Engineers Comments Regarding Surface Water Drainage

Application Reference:	BE/18/26/PL	Reviewer Reference:	ADC/EXT5/AF
Planning Officer:	Hebe Smith	Date of Review:	14/05/2026
Site Name:	Land West of 26 Greystone Avenue Bersted PO21 5EA		
Application Description:	Erection of 1 No. detached four-bedroom dwelling (self build) with associated car parking, bike store and landscaping. This application is in CIL Zone 4 and is CIL Liable as a new dwelling.		
Assessment Number:	1

A :: Proposed Ground Floor Plan
01 scale: 1:100

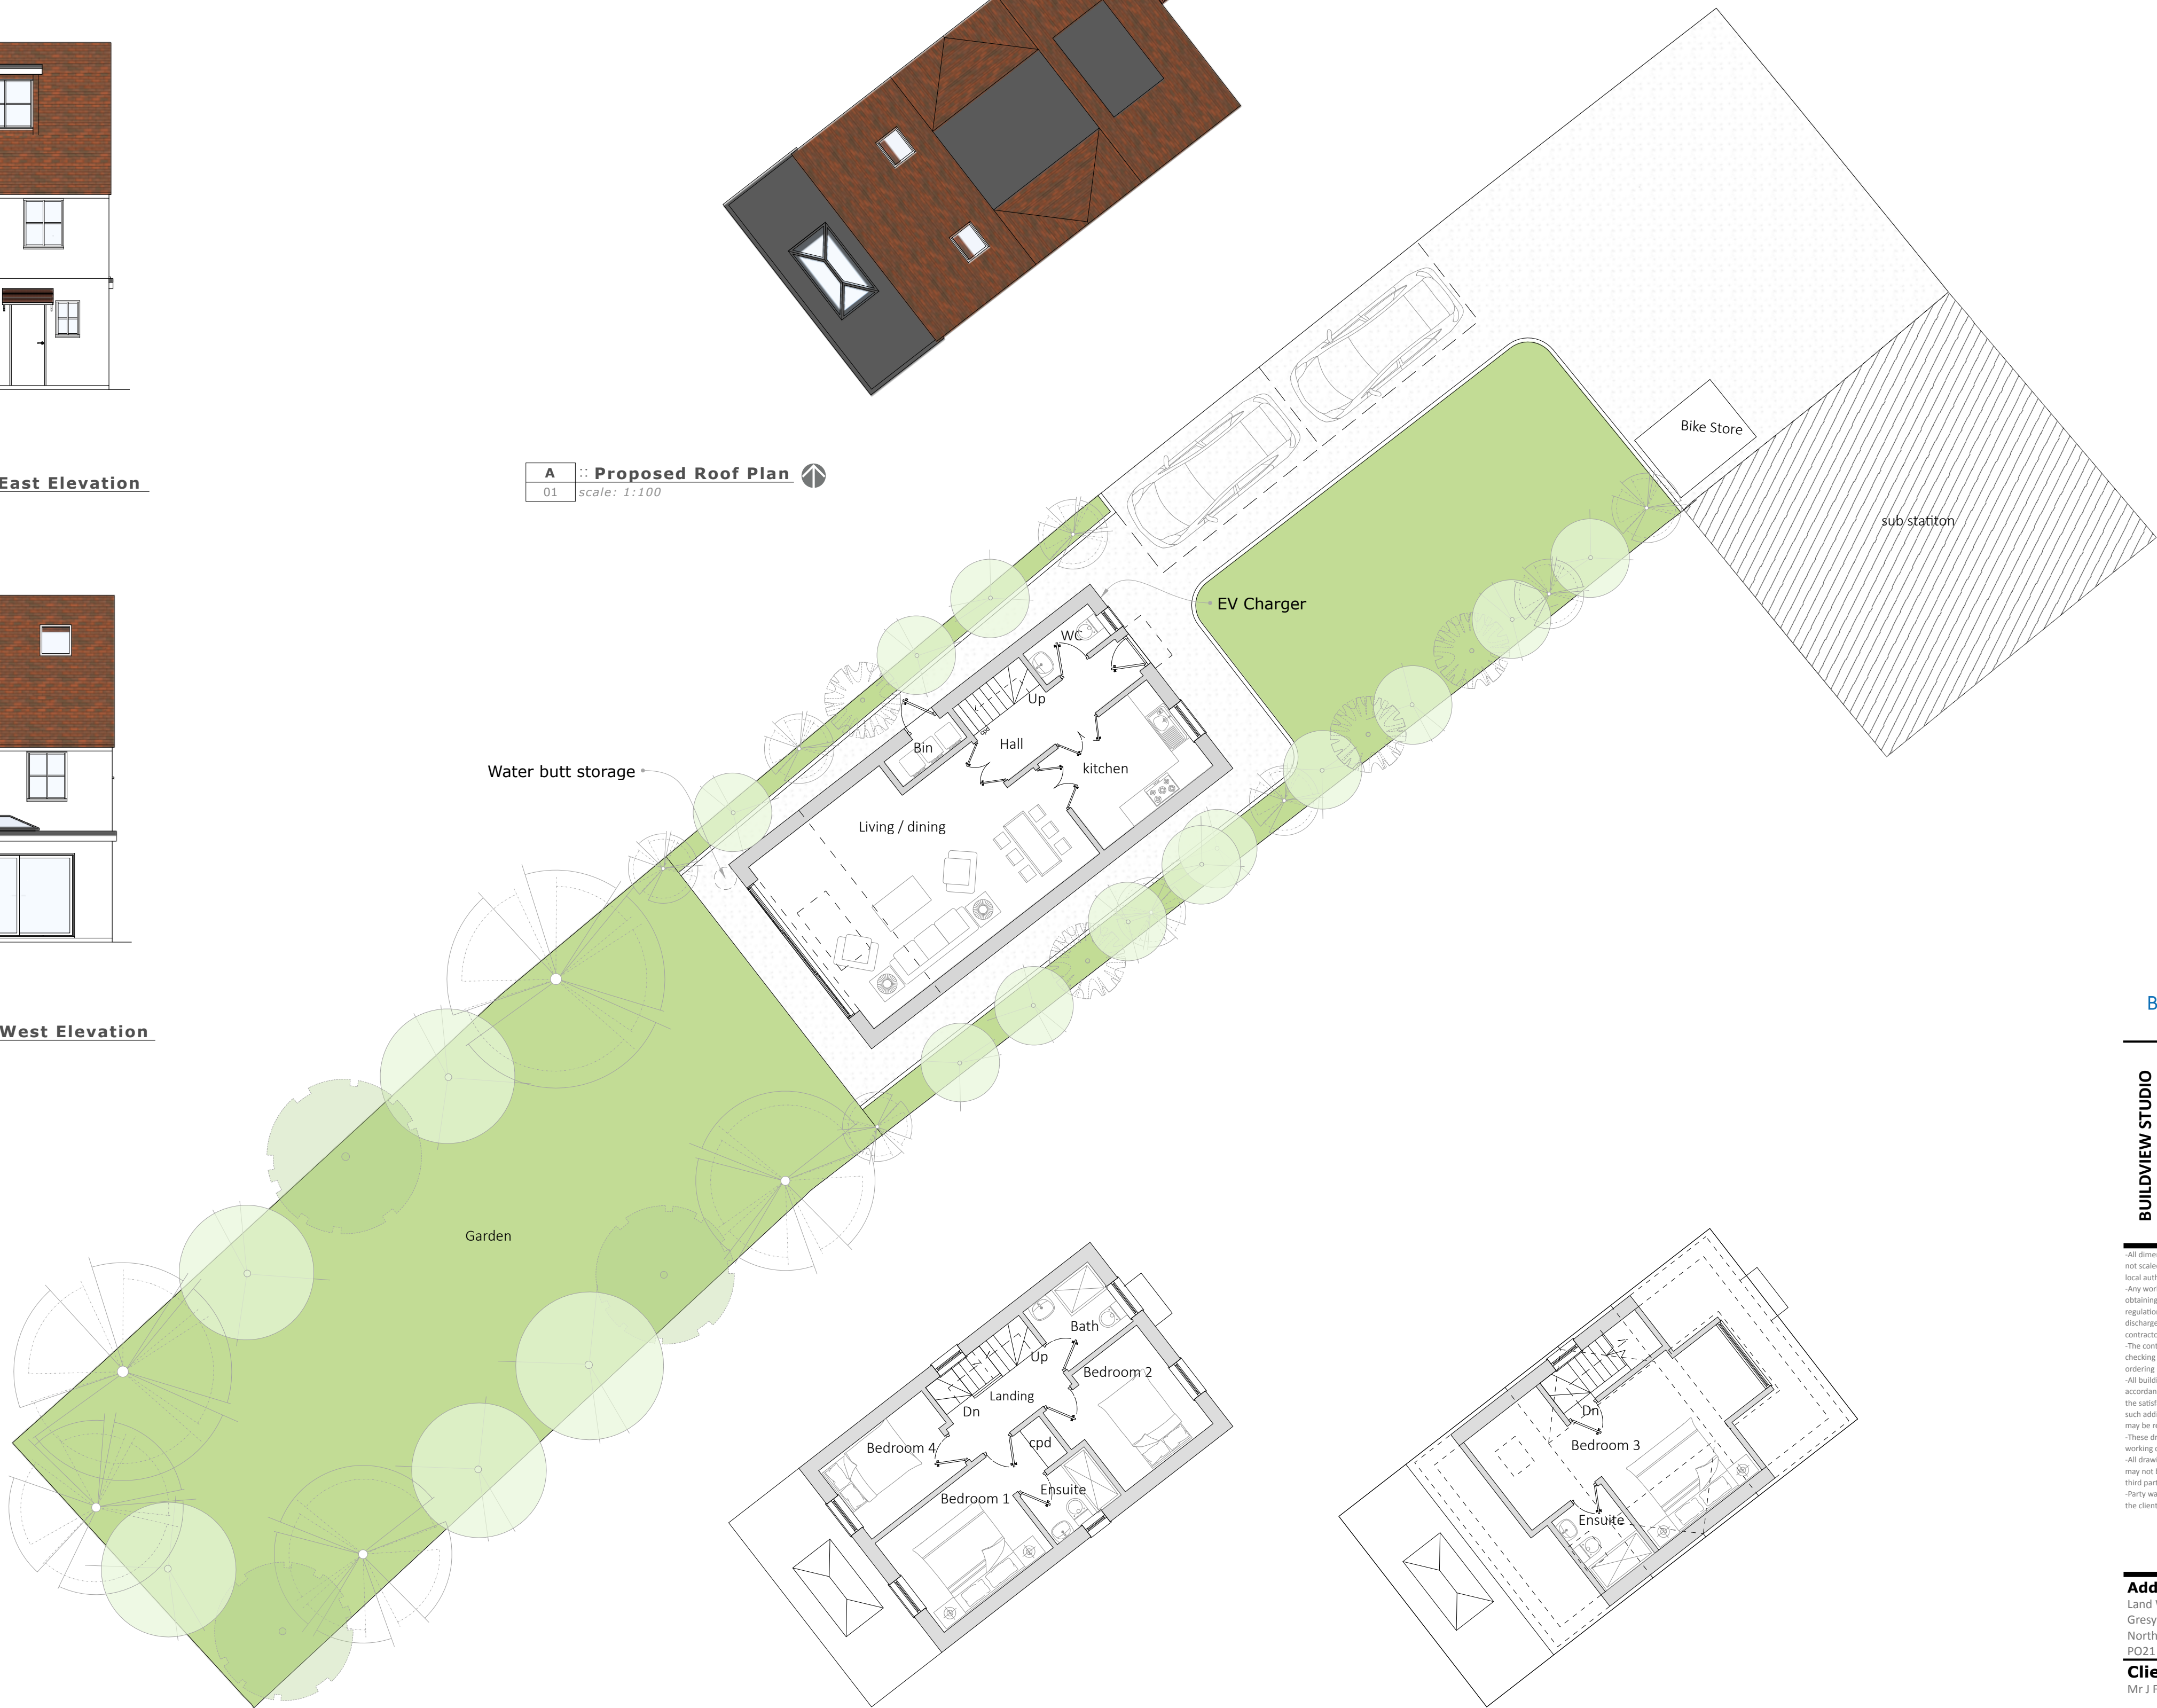
- 1.1. A water storage butt is shown on the layout plan, which is acceptable for small scale rainwater harvesting for a private dwelling.
- 1.2. The runoff destination should be established as part of the planning application in accordance with the NSfS. No information is currently provided.
- 1.3. The runoff destination is not currently in accordance with the requirements of the NSfS Standard 1. Therefore, we **object** to the application.

7.2. The building position appears to conflict with an existing culverted ordinary watercourse which has not been surveyed and shown on the plans. The Arun DC Land Drainage Act Bylaws [9] do not permit erection of a building within 3 metres of the enclosing structure of a watercourse without the prior consent of the Council.
